Online Comment

Application H09-0253-22
Location Plot 9 South Lincolnshire Food Enterprise Zone Off A151 Holbeach
Proposal Details of surface water drainage, scheme to deal with contamination and foul water strategy (Conditions 6, 8 & 12 of the LDO)

Name Sue Armour
Address Environmental Protection Officer SHDC

Date Submitted 11-04-22
For/Against Comments

Drawing Title:  
**PROPOSED OFFICE AND WORKSHOP  
PROPOSED GROUND FLOOR SLAB  
GAS PREVENTION PLAN & PENETRATION DETAILS**

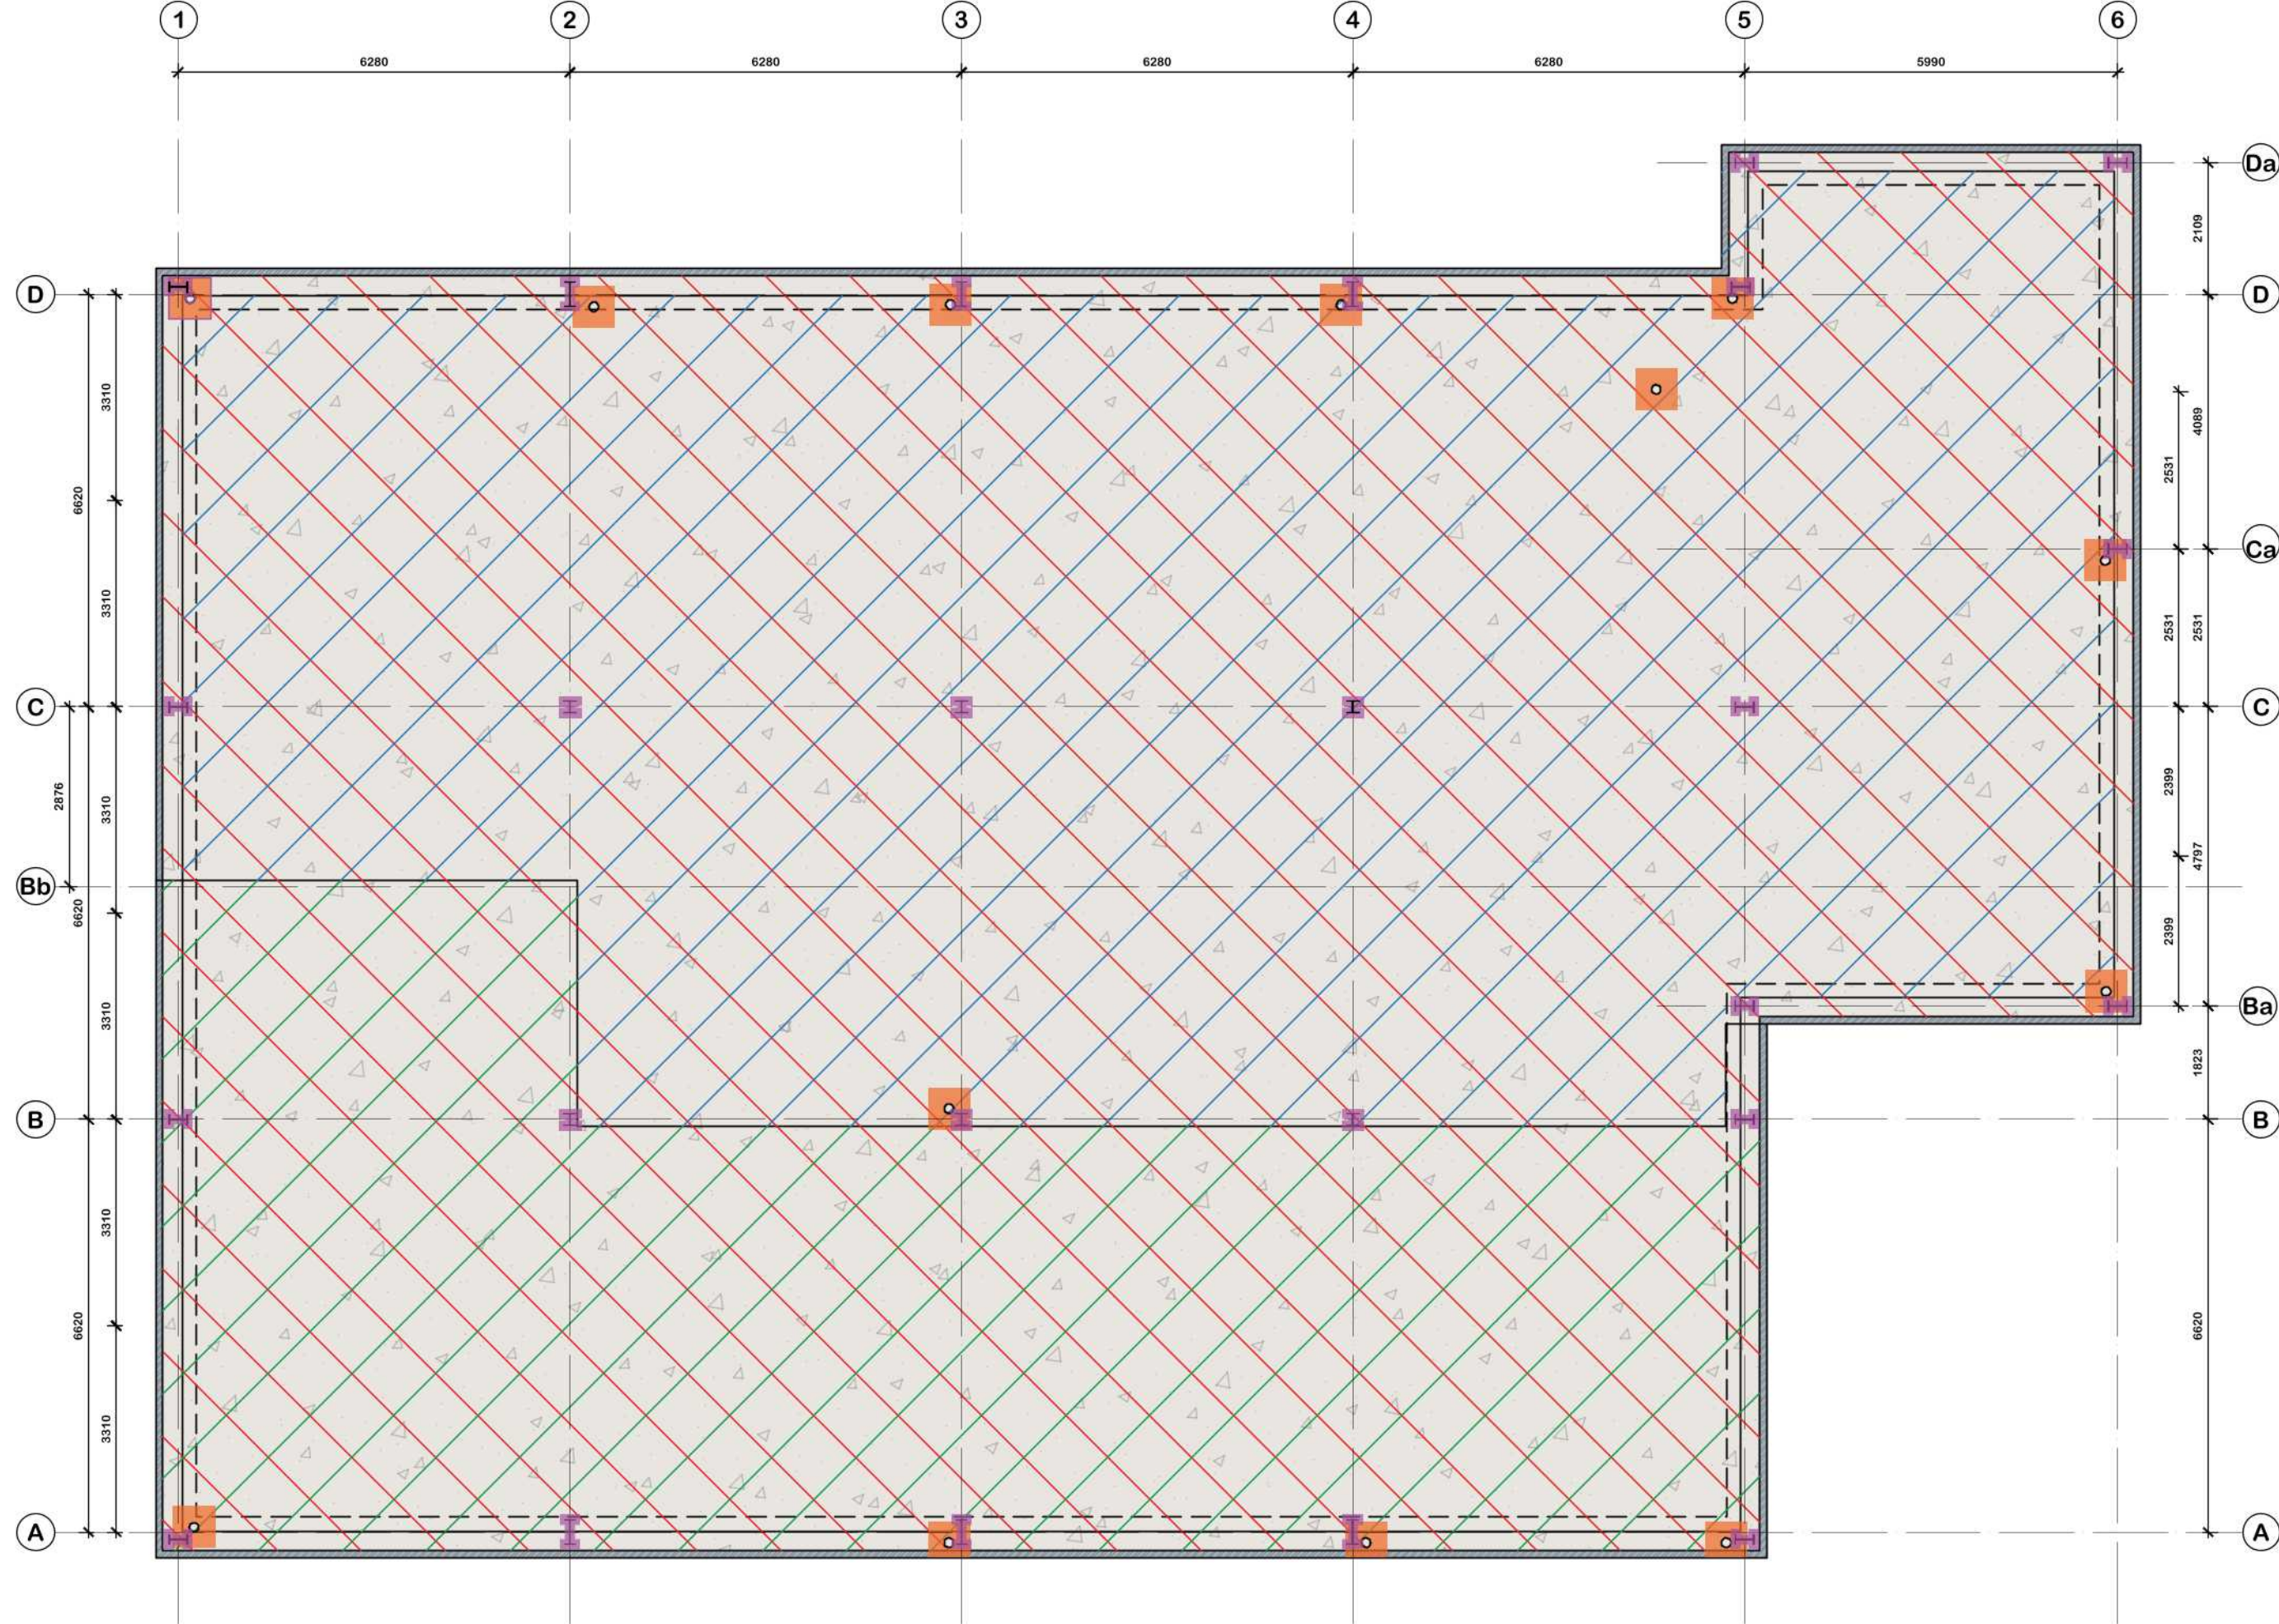
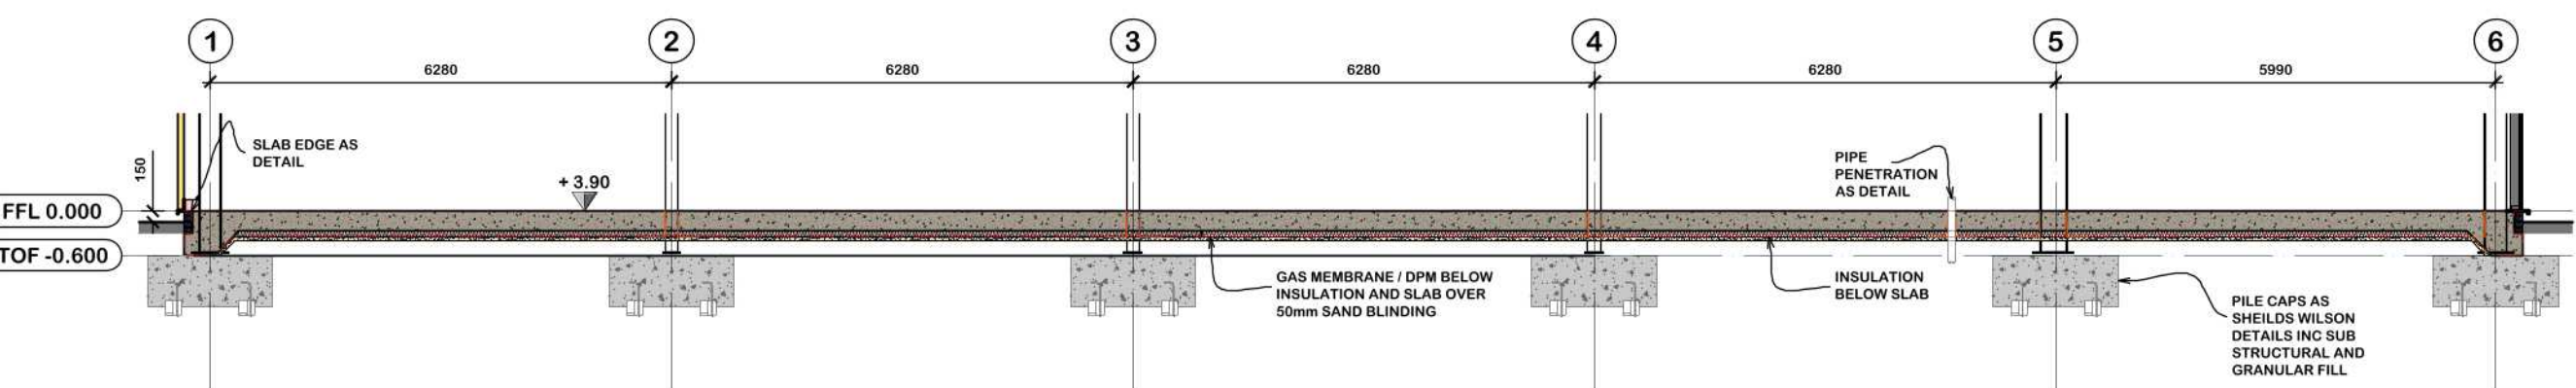
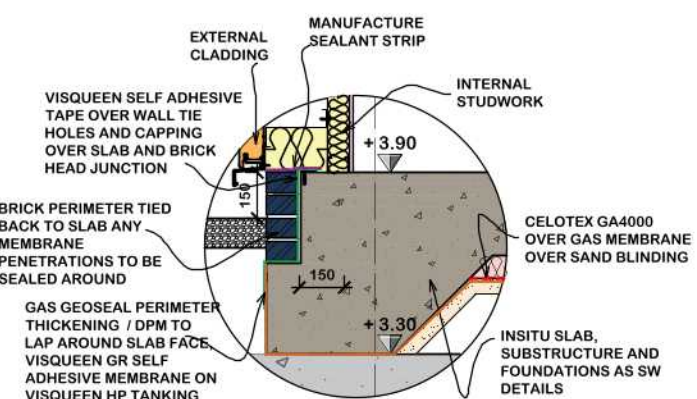
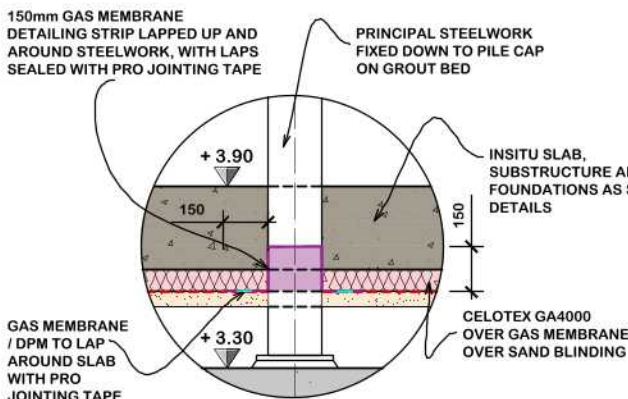
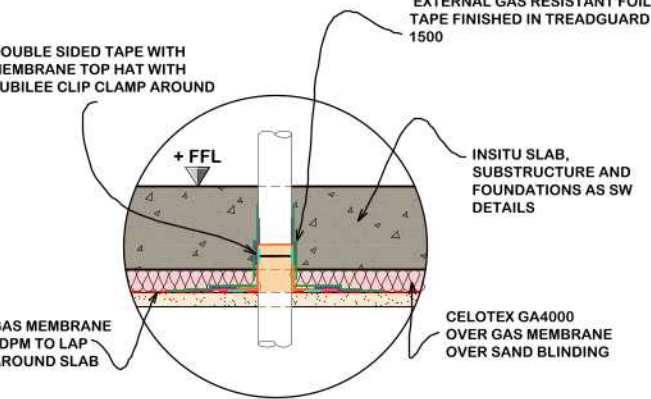
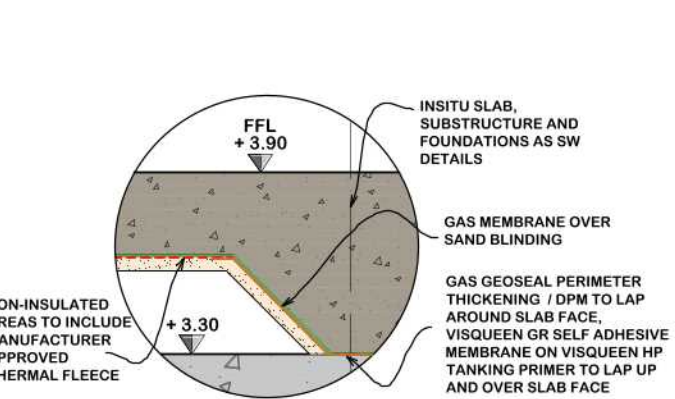
I have reviewed the Enviro Solution 'PHASE 1 ENVIRONMENTAL SITE ASSESSMENT REPORT HOLBEACH FOOD ENTERPRISE ZONE, LAND OFF A151, SPALDING, PE12 7BF' dated 26th January 2022 ref CL101 version 1 and am in general agreement with the findings and this would satisfy part 8i of the Holbeach FEZ LDO conditions for plot 9. I have reviewed the Enviro Solution 'REMEDIATION STRATEGY & VERIFICATION PLAN HOLBEACH FOOD ENTERPRISE ZONE, LAND OFF A151, SPALDING, PE12 7BF' dated 4th March 2022. Whilst I am in general agreement with the remedial strategy proposed, further detail, as in the exact solution chosen, should be submitted in order to progress further. This should include drawings for use on site specifying which elements are to be incorporated in to the proposed ground gas protection measures. I look forward to receipt of this information.
